**Subject:** RE: Attached letter from Kirklees Council regarding application number 2023/91236 at location White Syke Farm, Marsden Lane, Marsden, Huddersfield, HD7 6AF  
**Date:** 06 July 2023 16:12:11

Please arrange for the inclusion of the following conditions for the above site:

White Syke Farm- Site Plan-Proposed Car Port  
(showing location of water course).

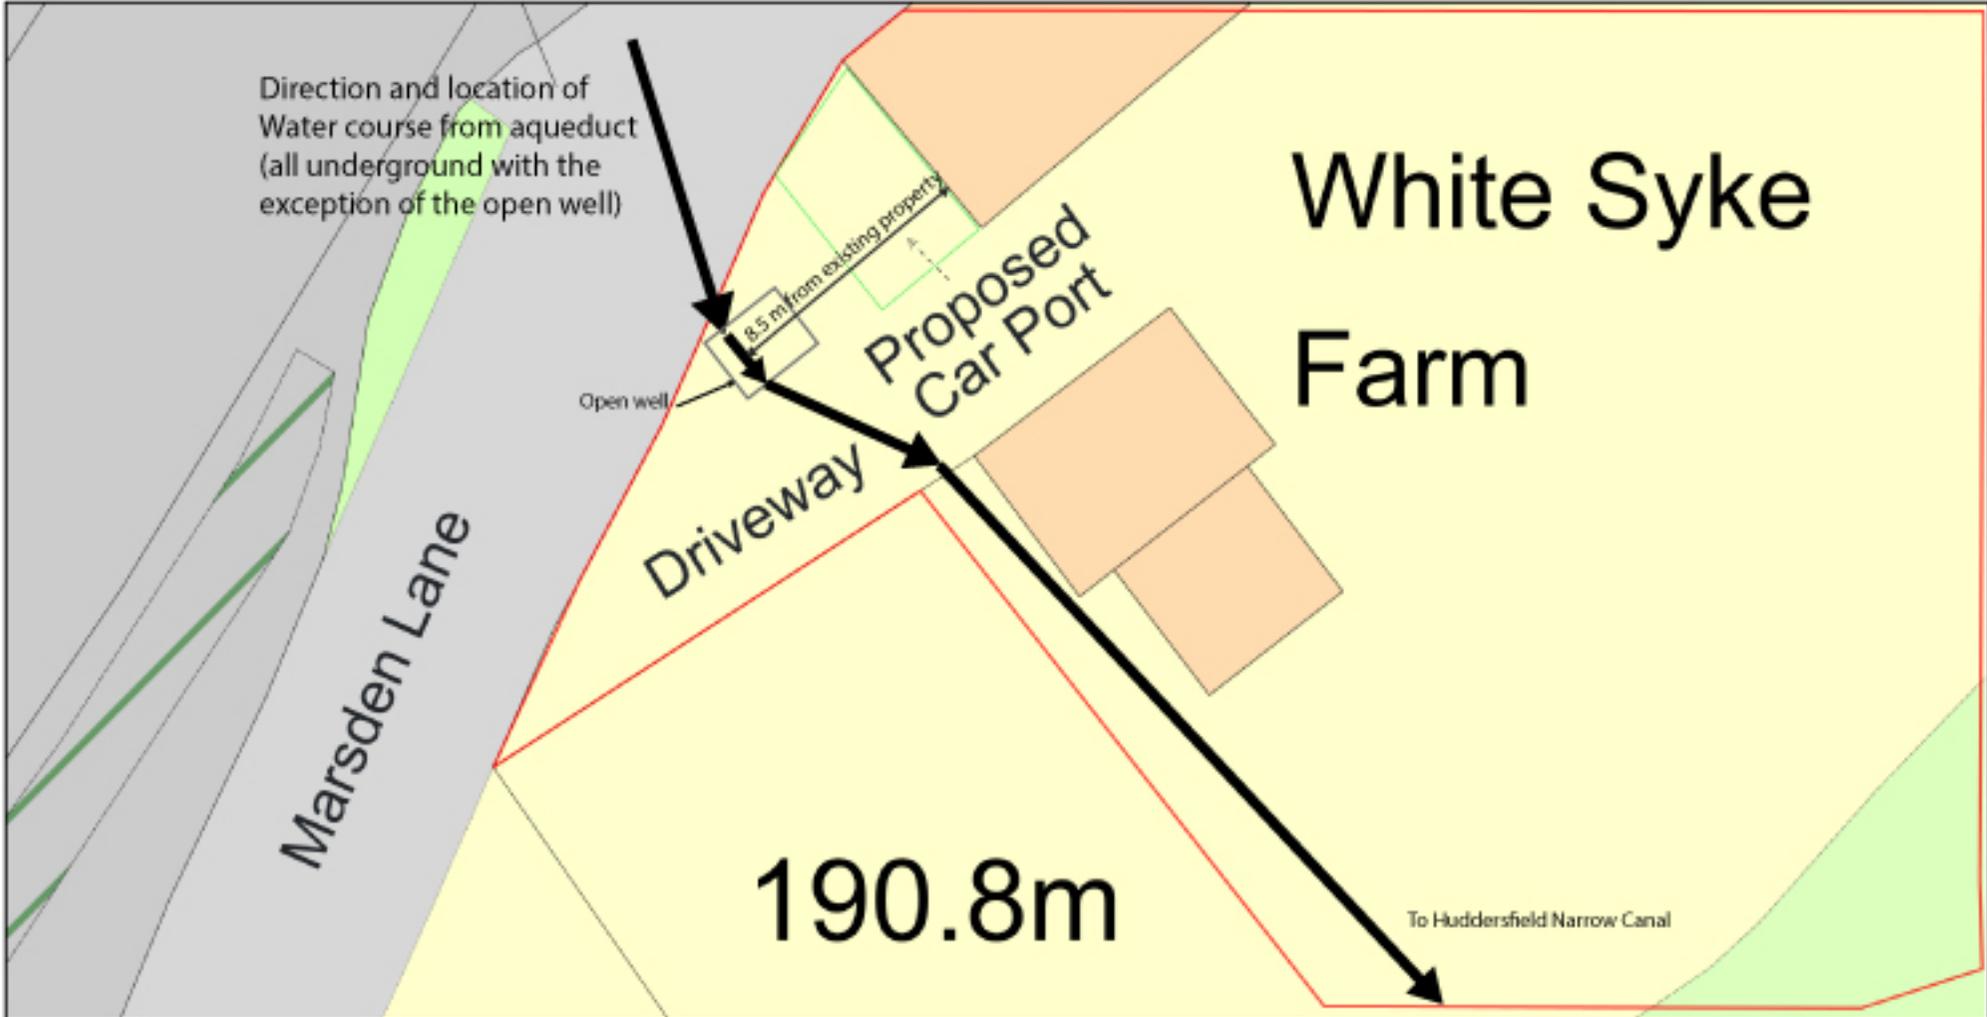
1. Before the development commences a scheme detailing the location and fully dimensioned cross-sectional information along with the proposed design and construction details for all new retaining walls adjacent to the existing highway including any modification to the existing highway retaining wall supporting Marsden Lane shall be submitted (via the submission of an AIP) and approved by the Highway Authority in writing. The approved scheme shall be implemented prior to the commencement of the proposed development and thereafter retained during the life of the development.

2. Before the development commences, a full structural dilapidation survey of the existing highway retaining wall supporting Marsden Lane shall be undertaken by a suitably qualified and experienced structural engineer and a copy of the report submitted to the Highway Structures team for record purposes. A further structural dilapidation survey of the retaining wall shall also be required following the completion of the works and any defects arising in the highway retaining wall due to the works associated with the proposed development shall be made good to the satisfaction of the Council's structures team, at the developer's expense.
